KIRKLEES METROPOLITAN COUNCIL INVESTMENT & REGENERATION SERVICE

DELEGATED DECISION TO DETERMINE PLANNING APPLICATION FOR ADVERTISEMENT CONSENT

Reference No:	2026/64/91800/W
Site Address:	747, Manchester Road, Linthwaite, Huddersfield, HD7 5QQ
Description:	Advertisement Consent for installation of illuminated advertising display (within a Conservation Area)
Recommending Officer:	Ellen Gilbert

DECISION – REFUSED

Title
Proposed Site Plan

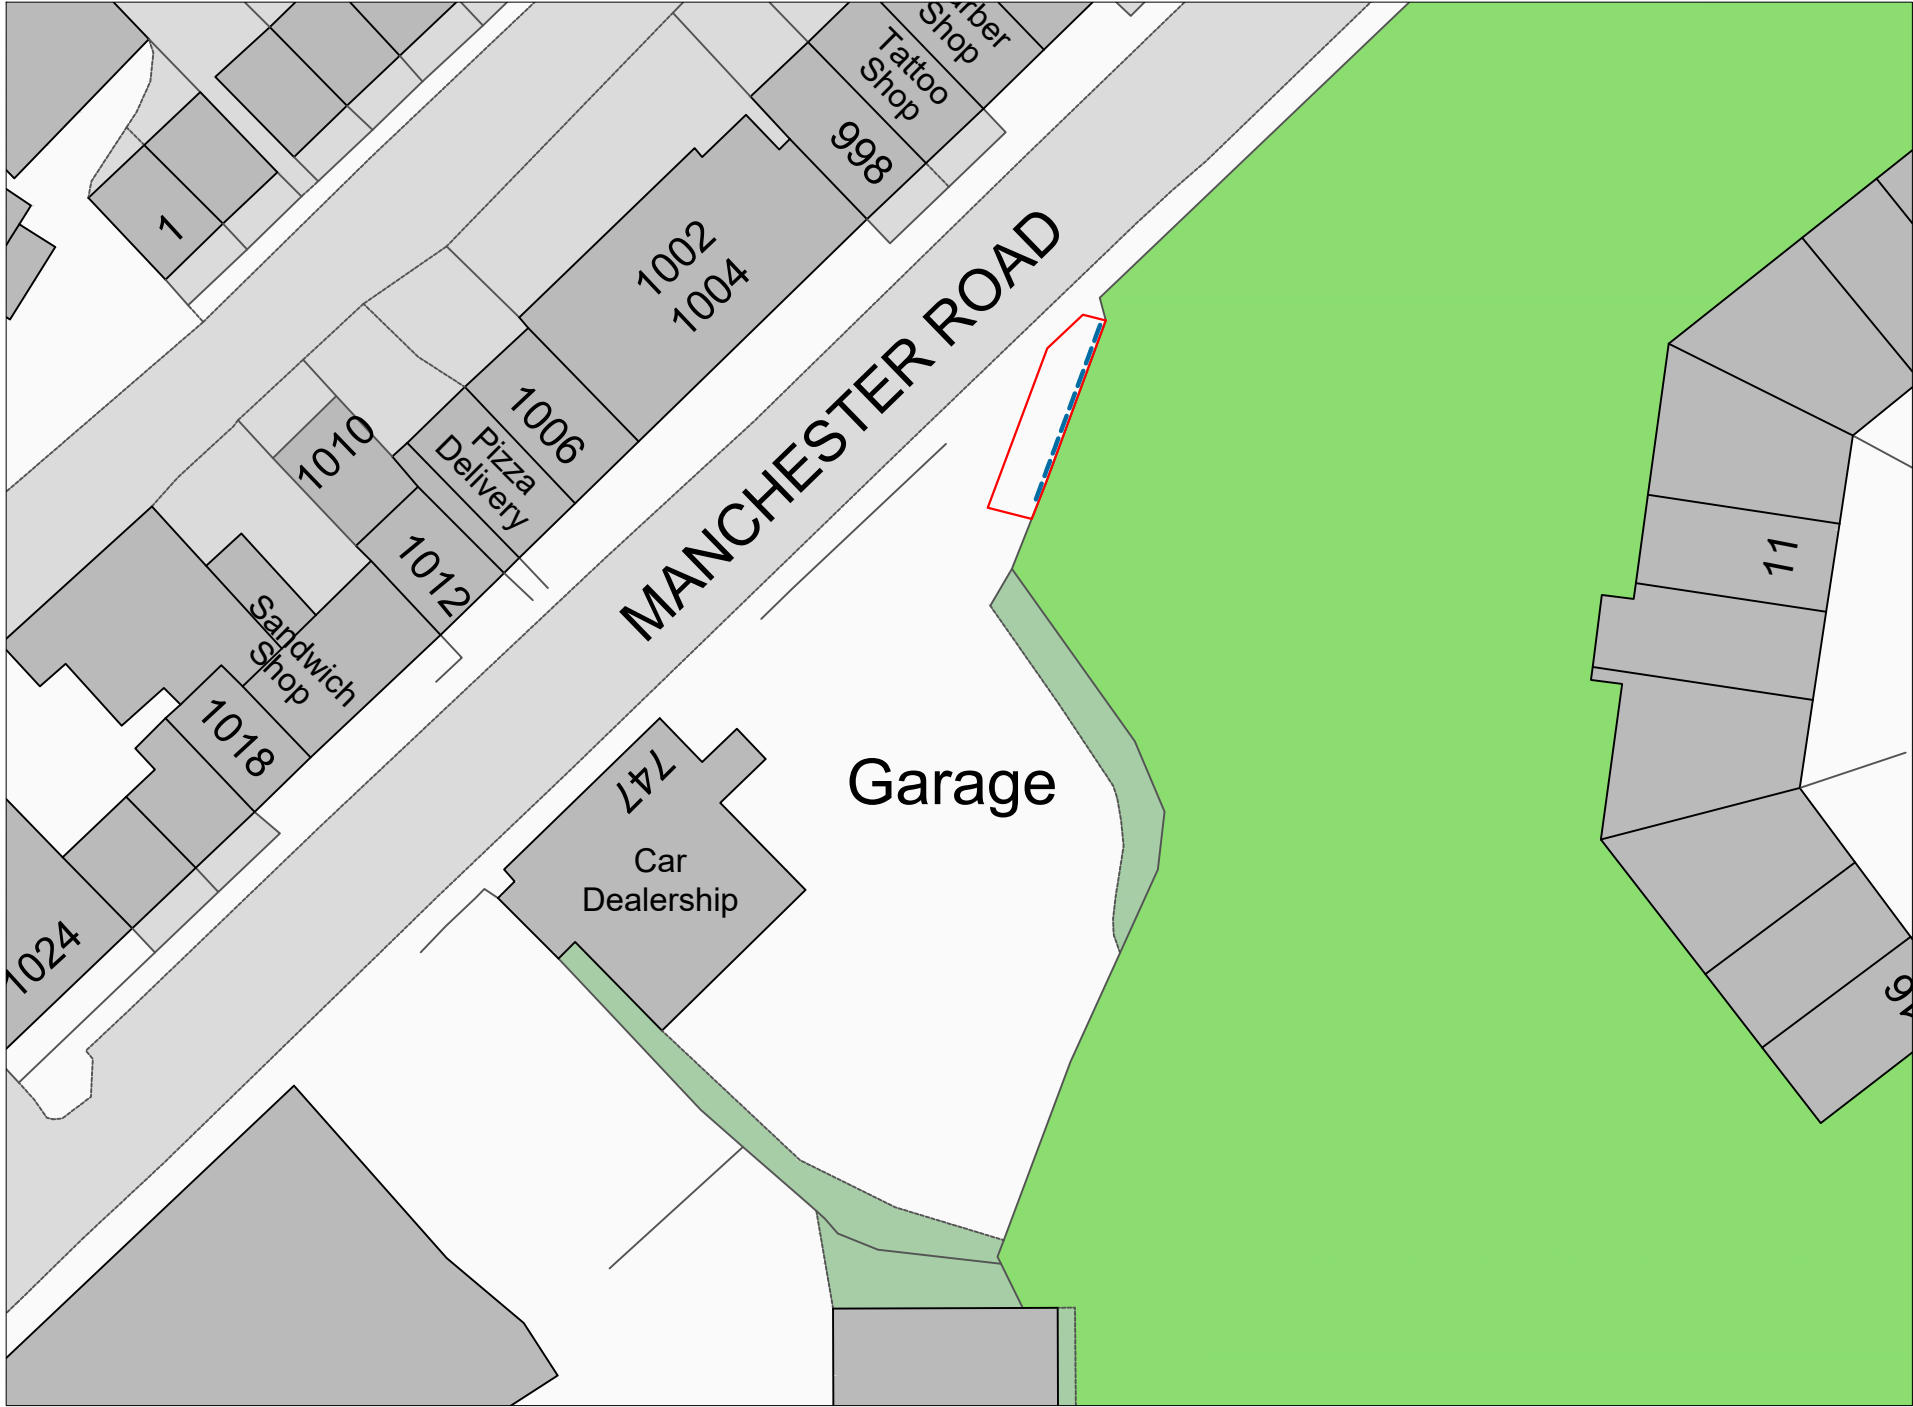
The proposal seeks to fix a two-dimensional, paper paste advertising display measuring 12m(w) x 3m(h) x 0.061m (d) and positioned 0.75m above ground. The display will be externally illuminated. The display is situated adjacent to Manchester Road and will be highly visible to pedestrians and road users, given its highly prominent location along the main road. The proposal would sit in front of a large tree covered embankment which runs along the A62. The embankment has been deemed as making a positive contribution to the streetscape and visual appearance of the Conservation Area by the Planning Inspectorate in their consideration of the appeal to previous refusal 2025/90034.

Title
Existing and Proposed Elevations

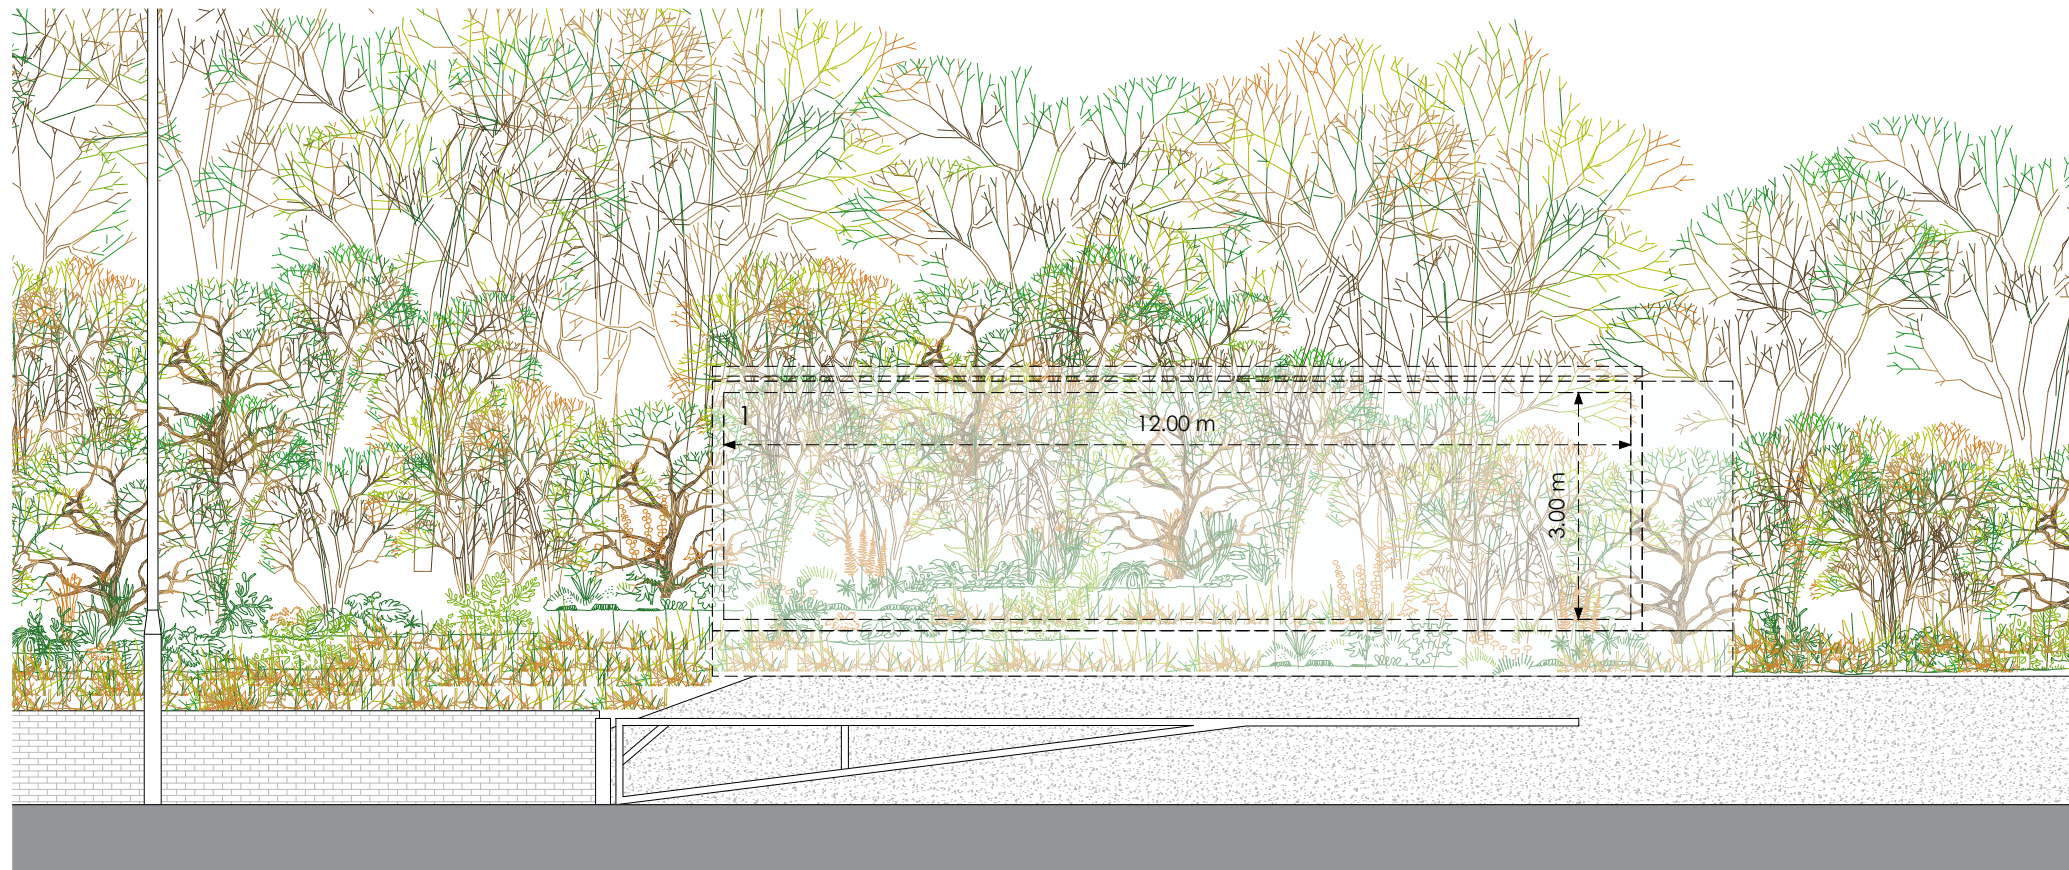
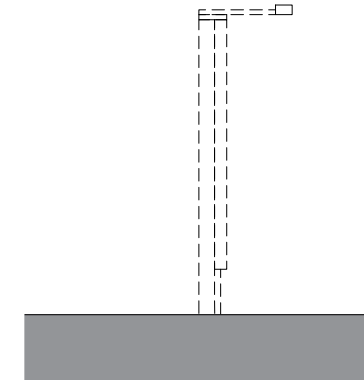
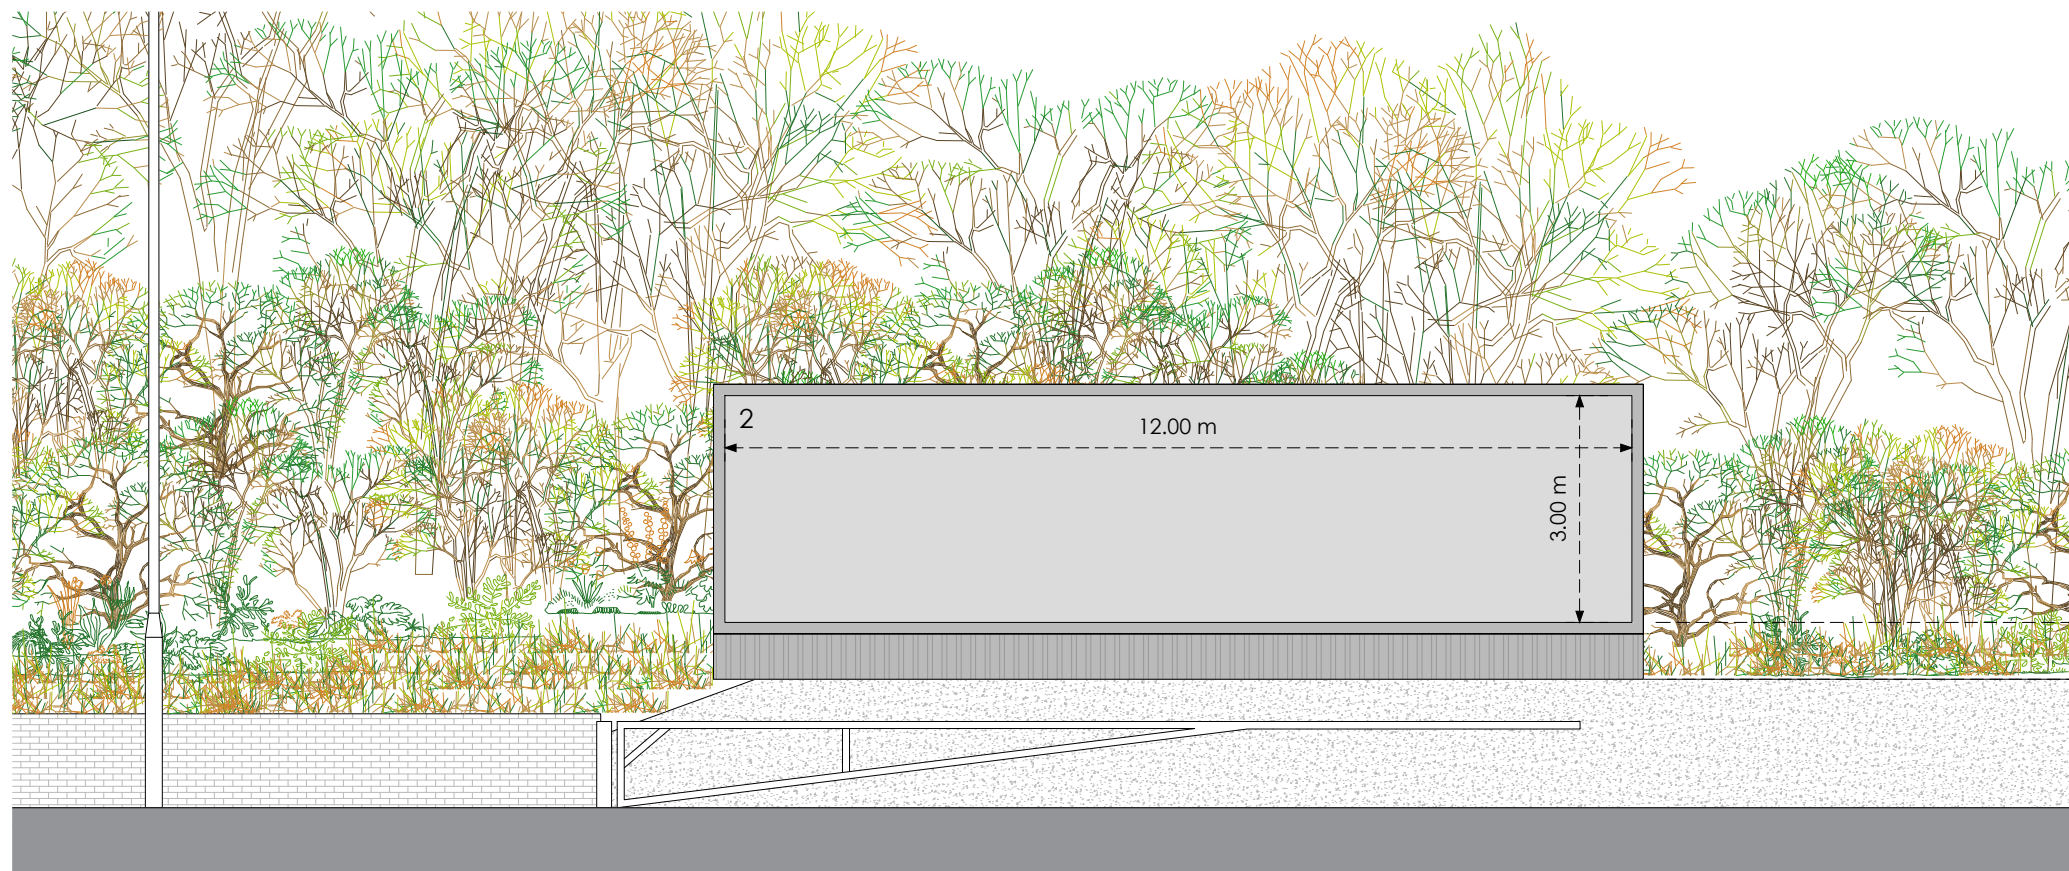
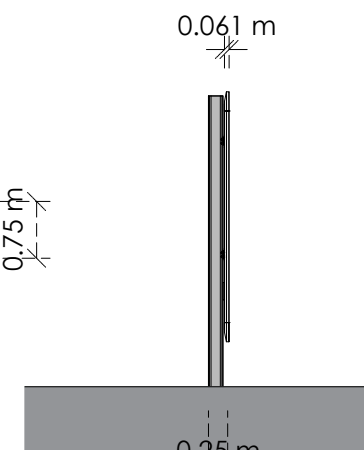
KC Conservation and Design were consulted on the subject of the application, and it was concluded that the reasons for the refusal of application 2025/90034 are still applicable in this case. Attention was drawn to the visually dominant and intrusive impact on the streetscape which would fail to preserve or enhance the Conservation Area. The impact of the overall size and method of display located in-front of the tree embankment was also highlighted as a negative impact on the visual amenity and character of the area.

1. The proposed advertisement, by virtue of its scale, illumination and prominent location, would form a visually jarring, intrusive and incongruous feature within the street scene, to the detriment of visual amenity and would fail to preserve the setting of Linthwaite Conservation Area, causing harm to its significance of which sufficient public benefits have not been demonstrated to outweigh the proposed harm. To permit such development would be contrary to Policies LP24 (a), LP25 1 (a) and (b) and LP35 of the Kirklees Local Plan, Section 66(1) of the Planning (Listed Buildings and Conservation Areas) Act 1990, and Policies within Chapters 14 and 20 of the National Planning Policy Framework.
